Sheringham Shoal and Dudgeon Offshore Wind Farm Extension Projects

The Applicant's comments on Oulton Parish Council's
Deadline 5 Submission

Document Reference: 20,11

TITLE  
B1149 OULTON  
DRAFT  
ACC25 ACCESS DESIGN  
(SHEET 2 OF 2)

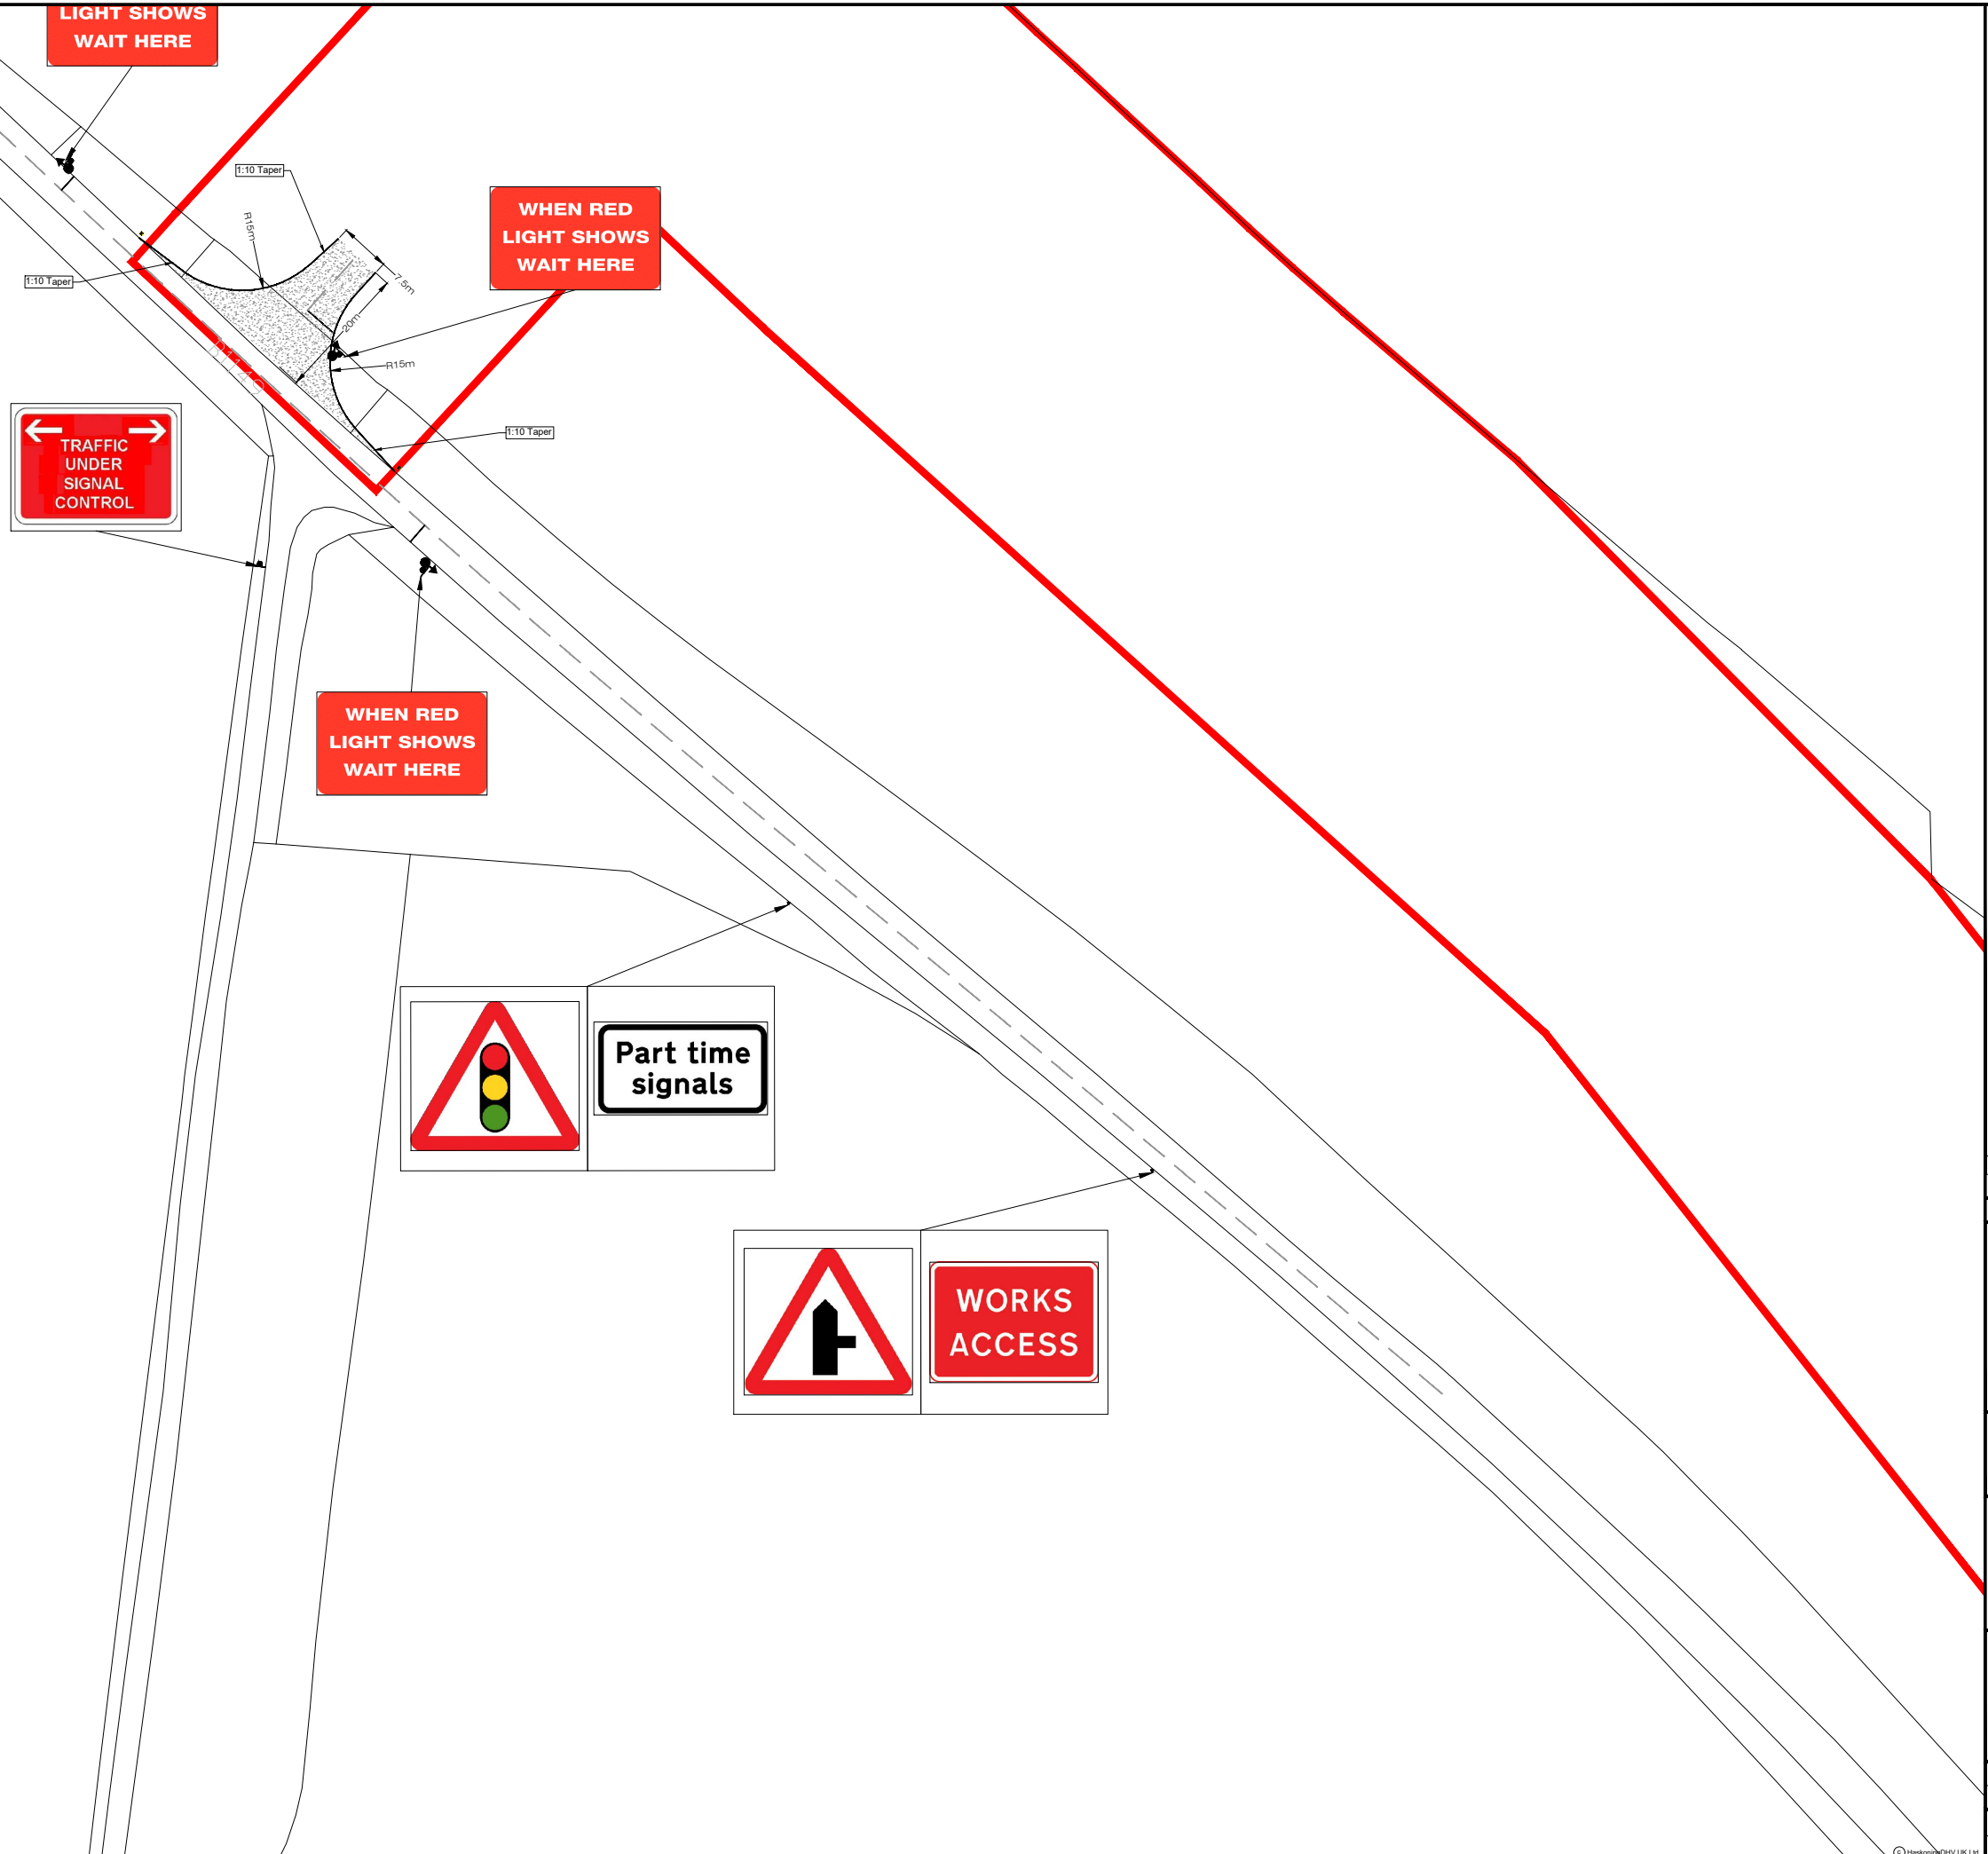
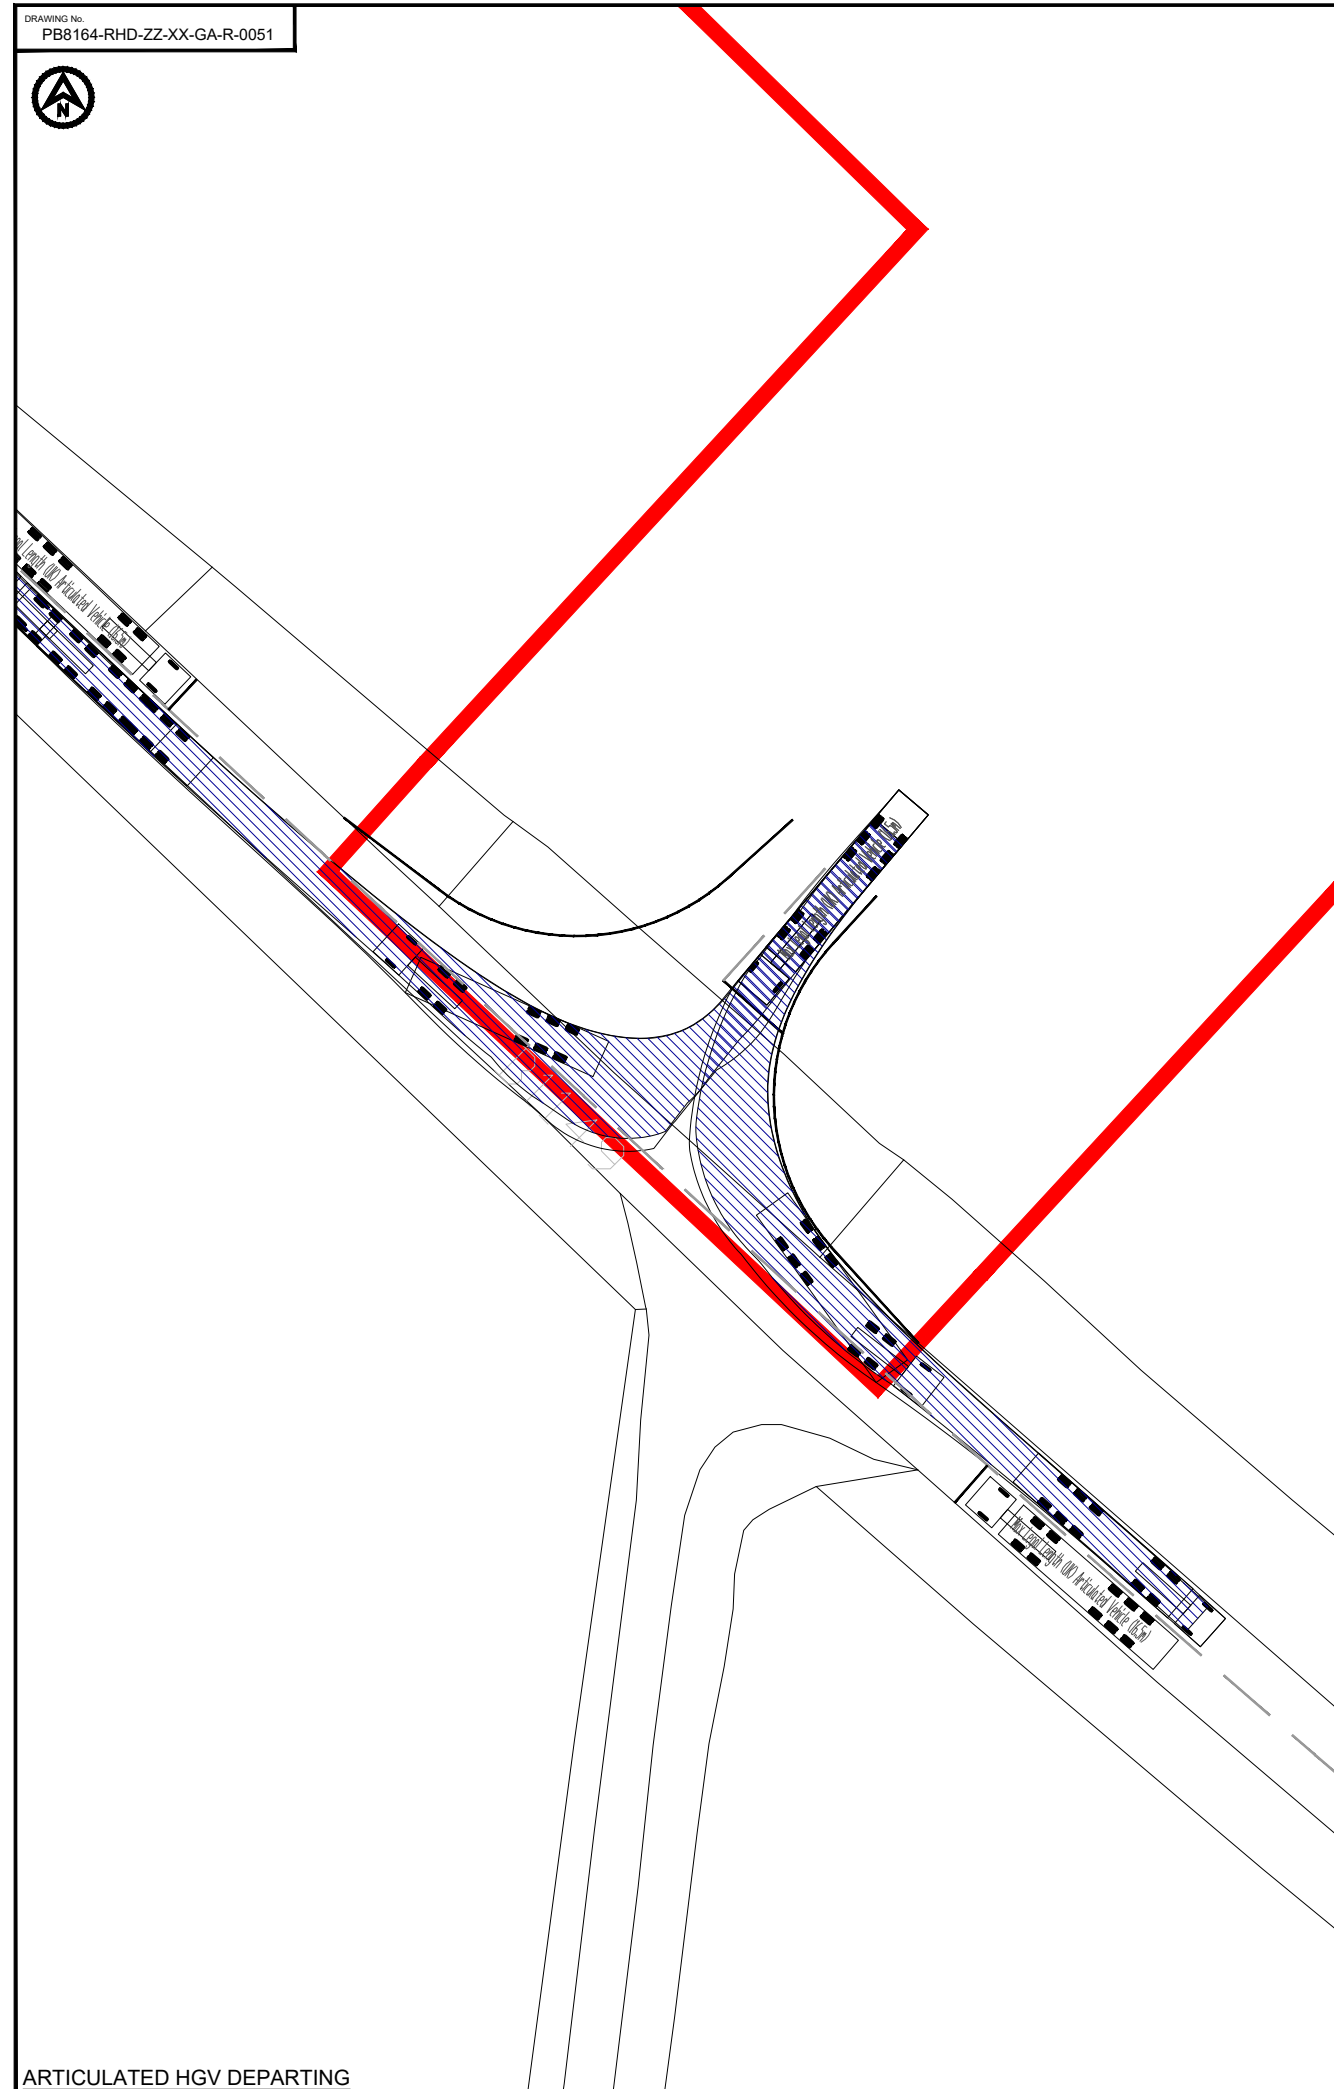
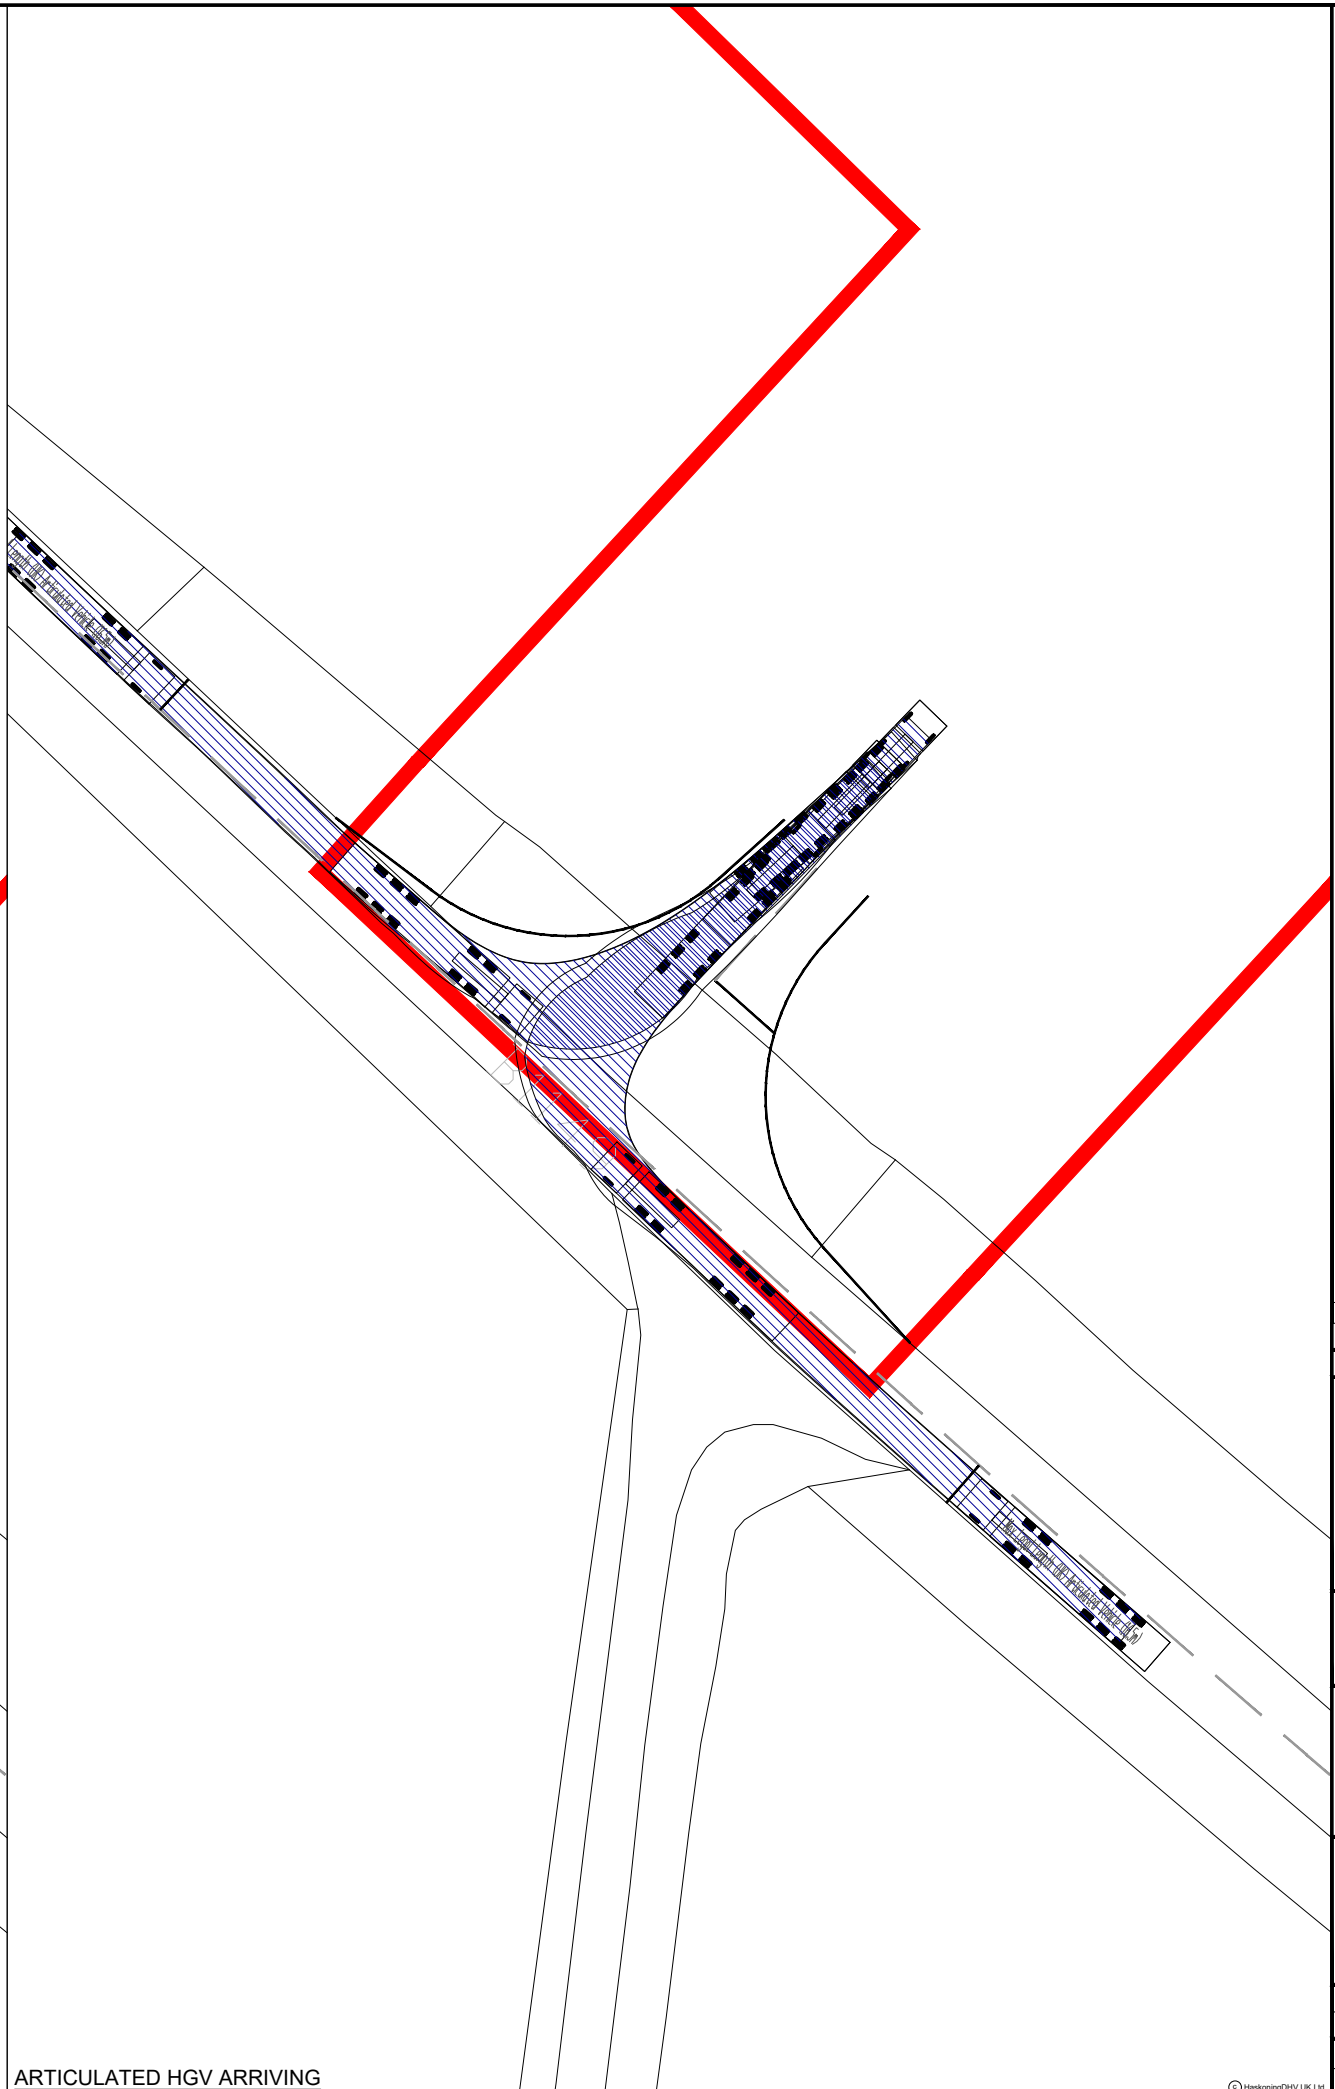
3	<p>Re: Q.2.23.5.5.</p> <p>The Applicant has answered the question which relates to ACC25B to Bluestone Cottage and access to the property.</p> <p>OPC have queries which relate to the proposed use of traffic signals for</p>	<p>It is anticipated that ACC25 will be utilised for a period of 6 months by construction traffic and ACC25b will be utilised for a period of 2 months by construction traffic. There will be a short duration (up to two months) where the accesses will be utilised at the same time.</p> <p>The applicant has agreed a traffic management strategy for ACC25 and ACC25b with Norfolk County Council to minimise disruption for highway</p>

ID	Stakeholder Comment	Applicant Response
	<p>ACC25 temporary compound <u>and</u> ACC25B cable route and HDD works.</p> <p>OPC note from the revised OCTMP (APP-301 revision C) submitted at Deadline 3, that there is mention of temporary traffic lights at ACC25B, along with plans (<i>pages 50-52</i>) for the traffic signalling and swept path information at this location.</p> <p>However, there are also plans for traffic lights at ACC25 (<i>pages 53-55</i>) which gives access to the temporary compound from B1149. The Applicant has not indicated whether ACC25 will be in operation at the same time as ACC25B. OPC would seek clarification on how the two sets of traffic lights will interact and how long the temporary compound will be needed for, and whether ACC25 traffic lights have the same restrictions as ACC25B?</p> <p>OPC can find no reference to time frames for temporary compounds. It was OPC's understanding that both accesses would <u>not</u> be in use at the same time.</p>	<p>users. It entails simultaneous operation of traffic signals for a short duration, restricted operating hours and manual control for ACC25b.</p> <p>Full details of the agreed traffic management strategy are contained in the Applicant's Deadline 5 Submission, Outline Construction Traffic Management Plan (Revision D) (Tracked) [REP5-028], Section 4.4 and agreement confirmed in the Draft Statement of Common Ground with Norfolk County Council (Revision D) [REP5-033], Section 2.3, ID 24.</p>

6	<p>OPC are unaware of this having been explained in the OCTMP. The Applicant will therefore need to explain the operational design for ACC25(temporary compound) with ACC25b (cable route/HDD), along with any cumulative impacts of traffic lights near to the junction of the B1149 with The Street and Link 131 (SEP/DEP), Link 68 (Vanguard/Boreas) Link 208 (Hornsea Three Main Construction Compound).</p>	
7	<p>Will traffic held at the traffic lights along the B1149 cause any tailback that might result in a blockage to the junction of the B1149 with The Street (Links 131/68/208 referred to above)?</p>	
8	<p>This could result in backups for traffic entering and exiting the junction or cause backups further along the B1149 at Cawston roundabout or Saxthorpe roundabout, especially in light of the huge increase in HGVs along this section of road, caused by the NSIPs, together with seasonal agricultural vehicles, and tourist traffic.</p>
